**\*PRE-HEARING STAFF ANALYSIS\***

**Rezoning Petition No. 2008-036**

**Request:** I-1 (CD), light industrial conditional to I-2 (CD), general industrial conditional district

C1.0

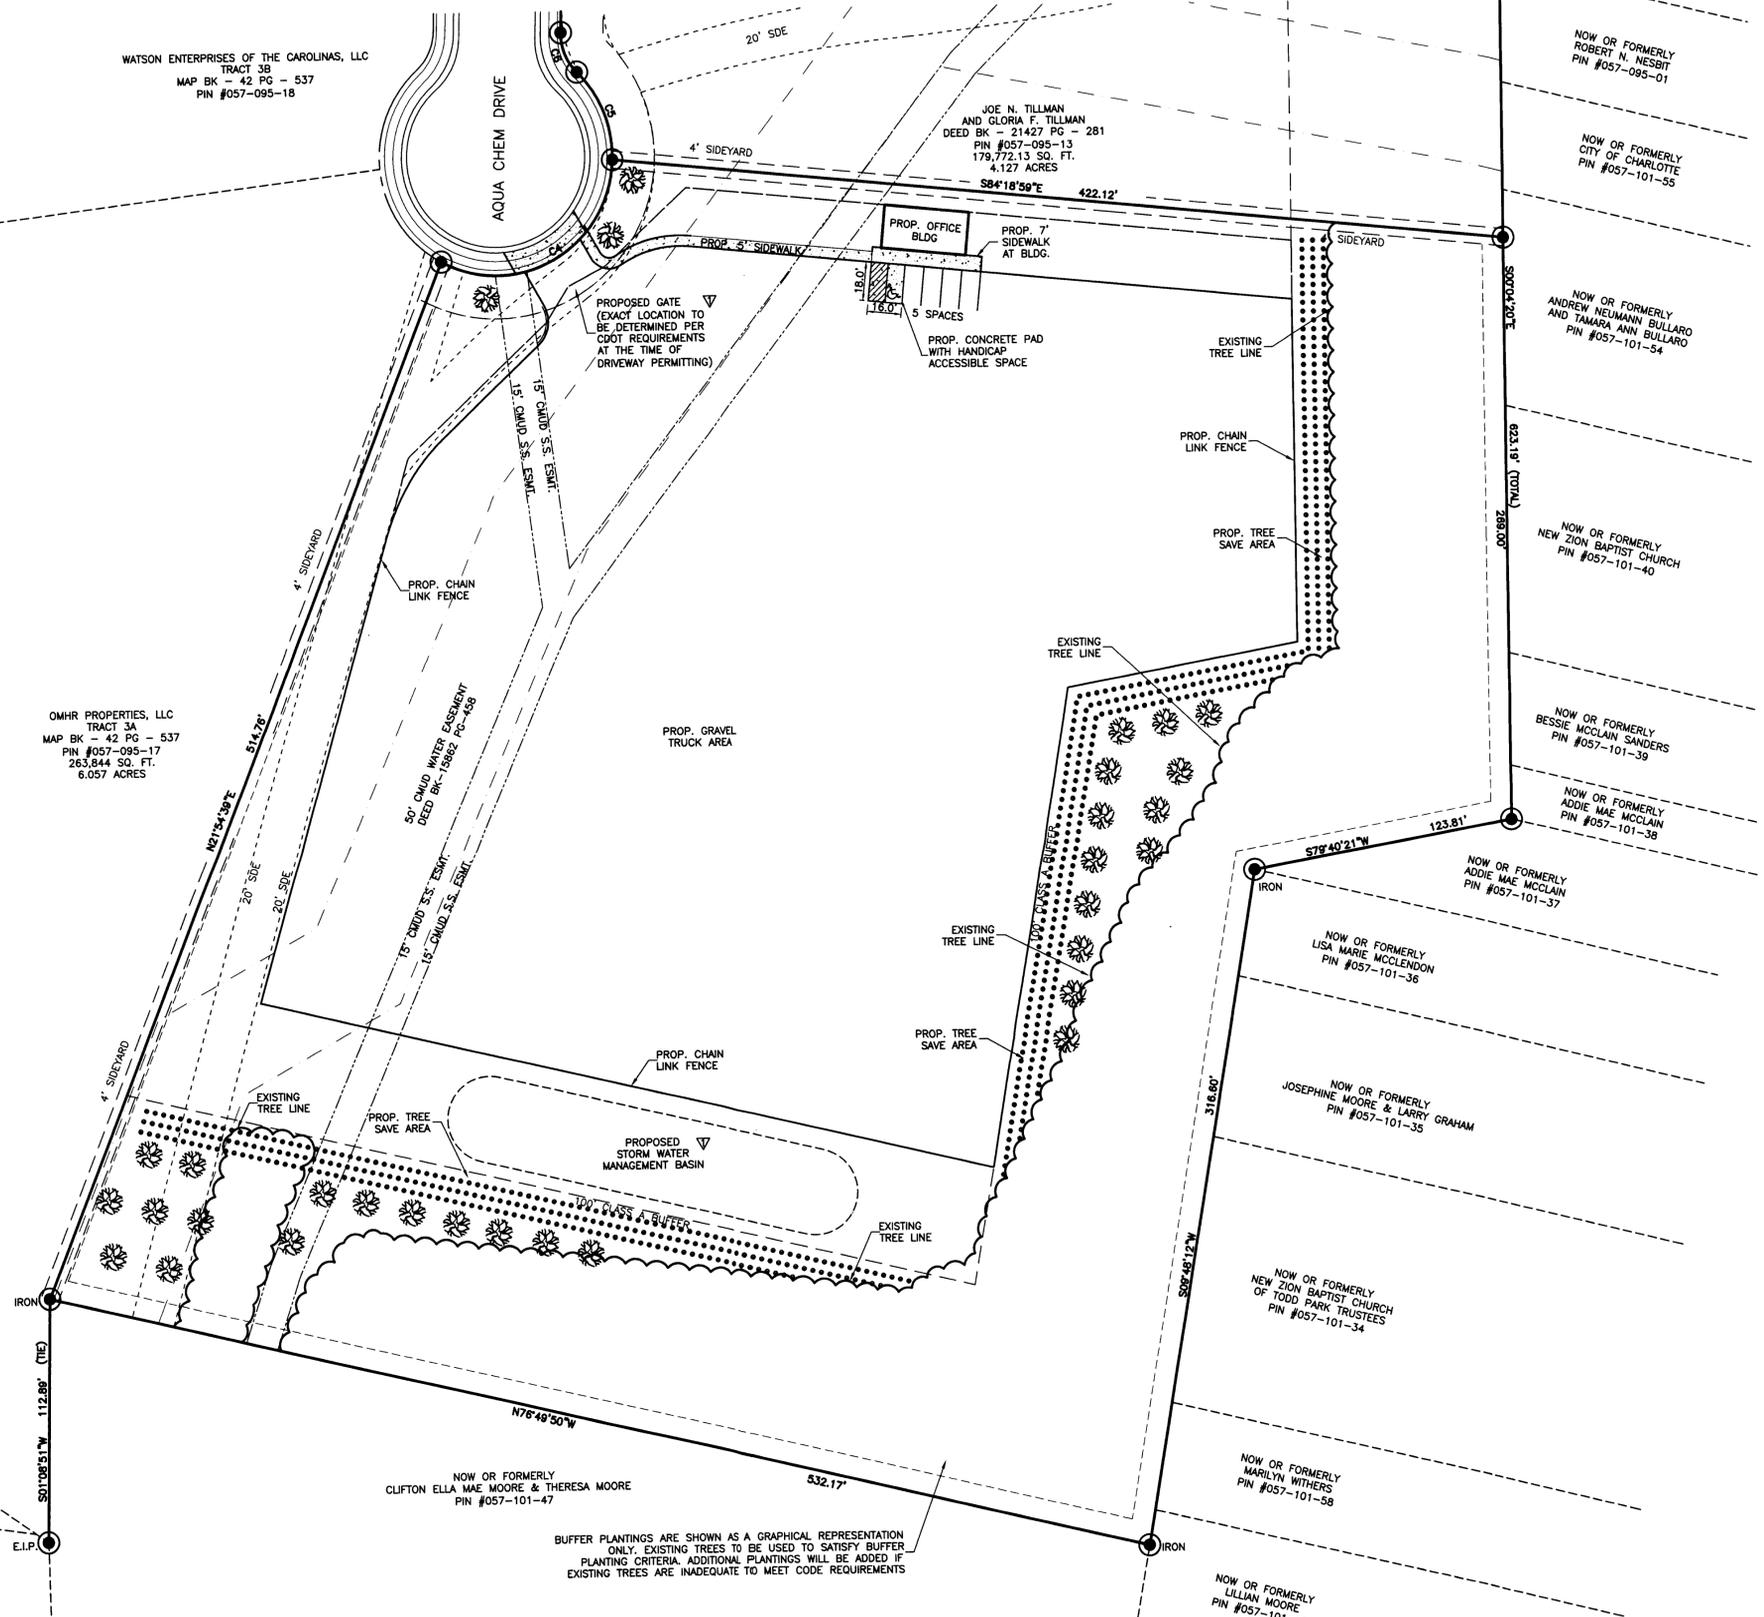
- Under the “Conditional Notes” states that the use will be a truck terminal/truck parking. This should be removed or modified to include all uses in the I-1 as the note under the “Development Data” indicates.
- A note should be added that Storm Water detention facilities will not be located within the required buffer.
